Application no: **3/2023/0946**

Address: **Moorcock House Slaidburn Road Waddington BB7 3AA**

Proposal: **Retention of re-positioned access gate and stone track off Slaidburn Road.**

The Local Highway Authority have viewed the plans and highway related documents and have the following comments to make:

Proposed Access
Scale 1:500 @ A3

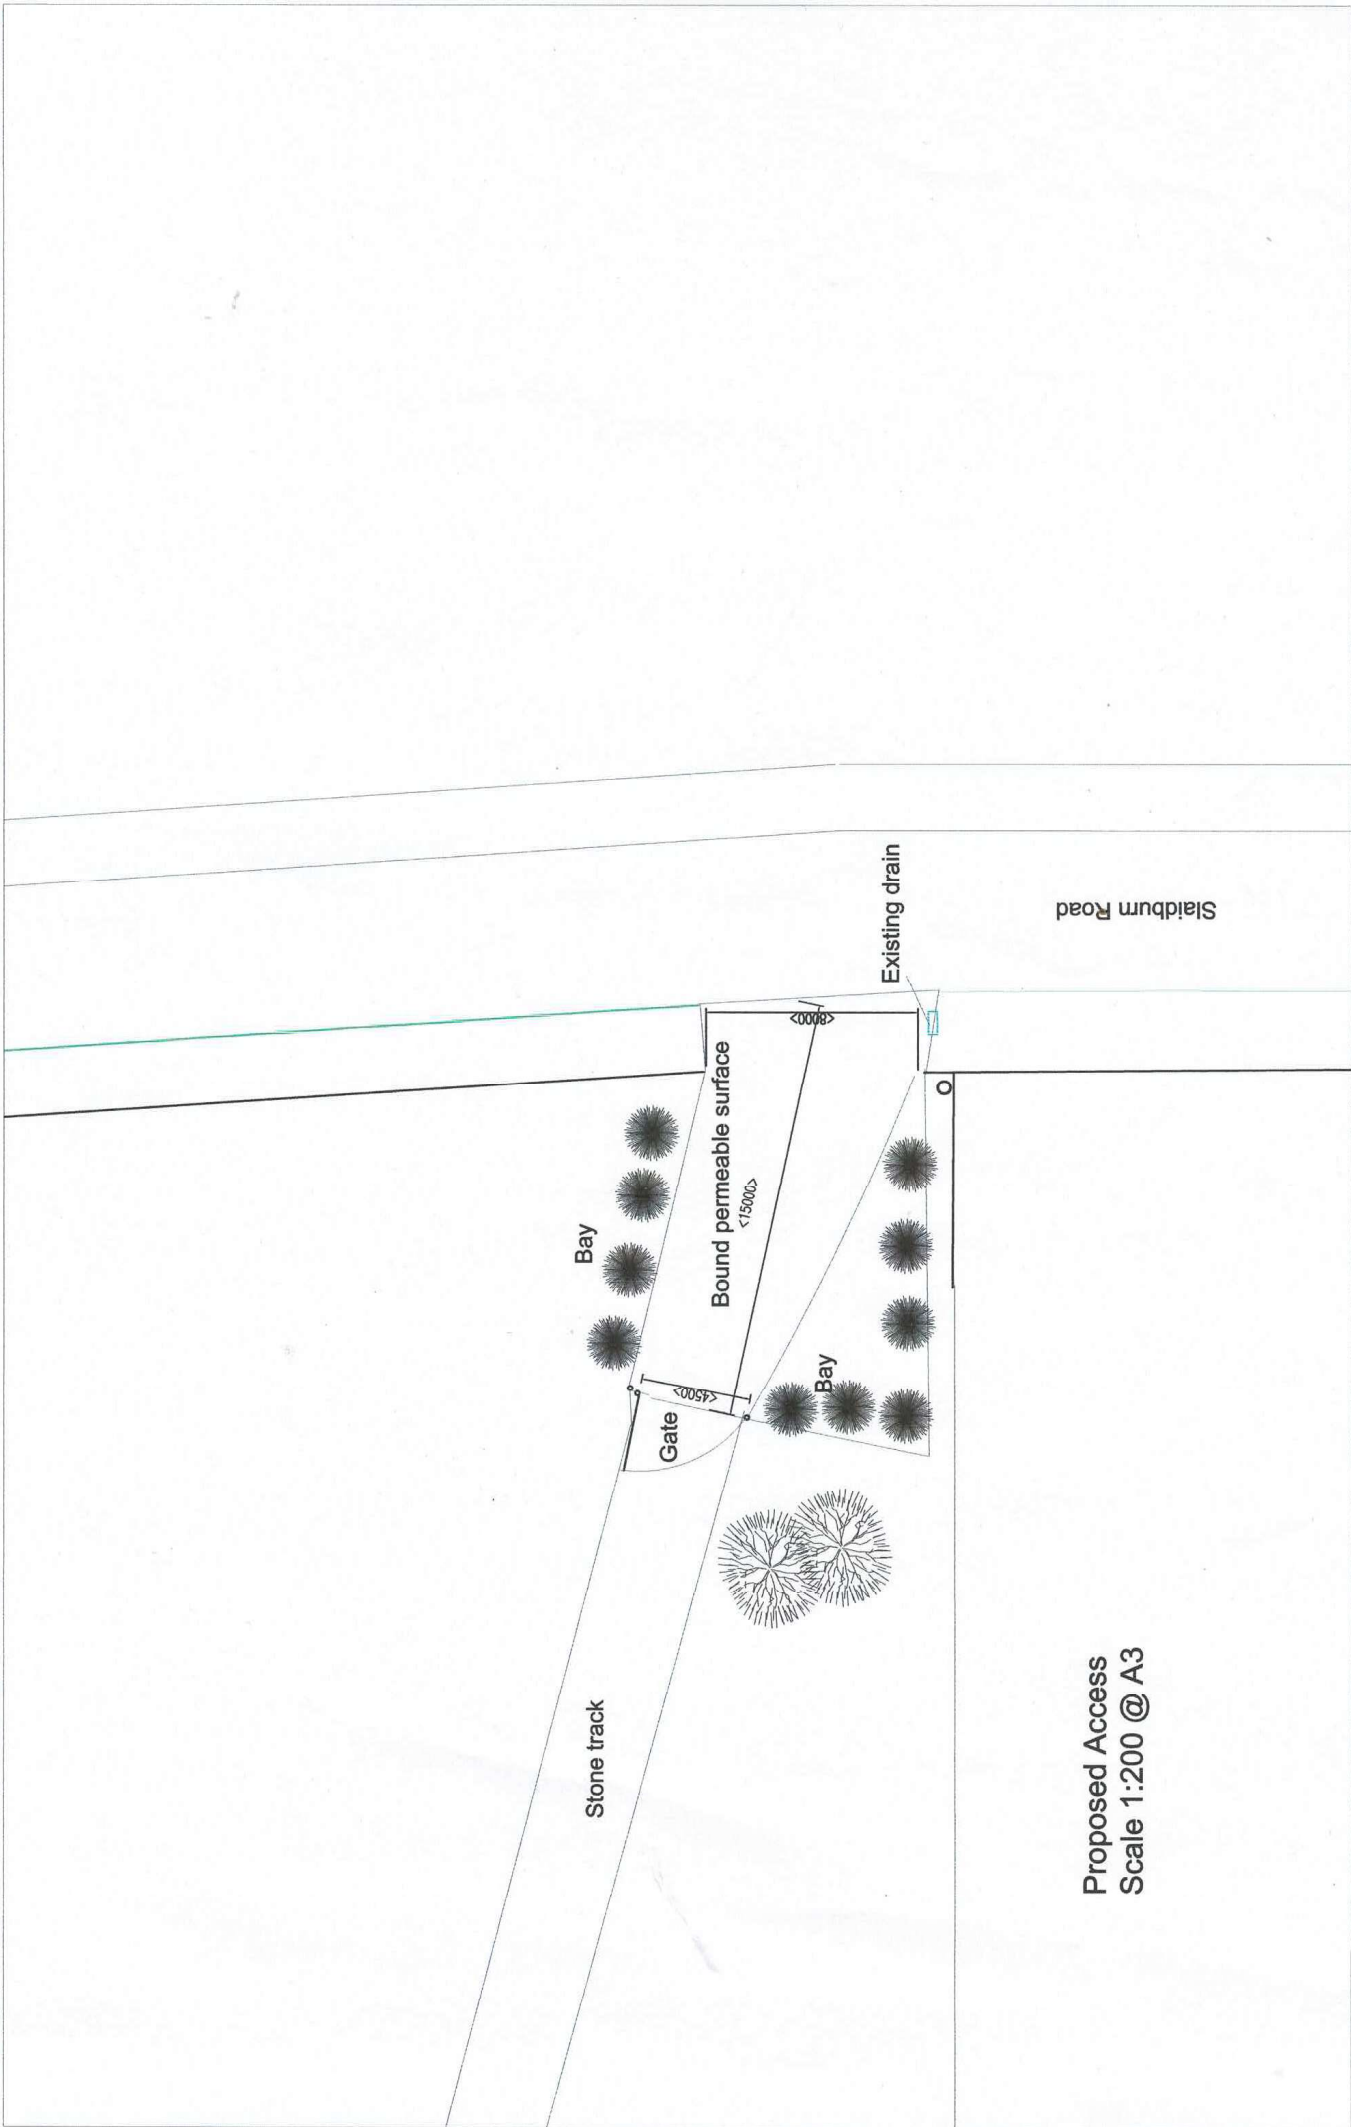
The LHA have reviewed the drawing titled "Proposed Access" and note that the access width will be increased to 8m wide and this width will eventually reduce to 4.5m, a distance of 15m from the adopted highway. The access will then be served by a gate.

Before the LHA can comment on the suitability of the access, the LHA require further information regarding the use of the site. This is because the setback distance of the gate and the access width seems slightly excessive should the access just serve the agricultural field. Therefore, further information is required regarding the use of the access.

The LHA also require a visibility splay drawing to be submitted following the alteration to the access. The LHA require visibility splays of 2.4m x 214m in both directions and anything within these splays need to be no higher than 1m to prevent any obstructions to visibility.

Should the access not be able to achieve the required visibility splays and the use of the access is intensified following the proposal, the LHA will require a traffic survey to be conducted within the vicinity of the site. This should demonstrate the 85th percentile speeds along Slaidburn Road and will help set the required visibility splays for the site.

- Operation Statement detailing the use of the site.
- Visibility splay drawing.
- Access track drawing.
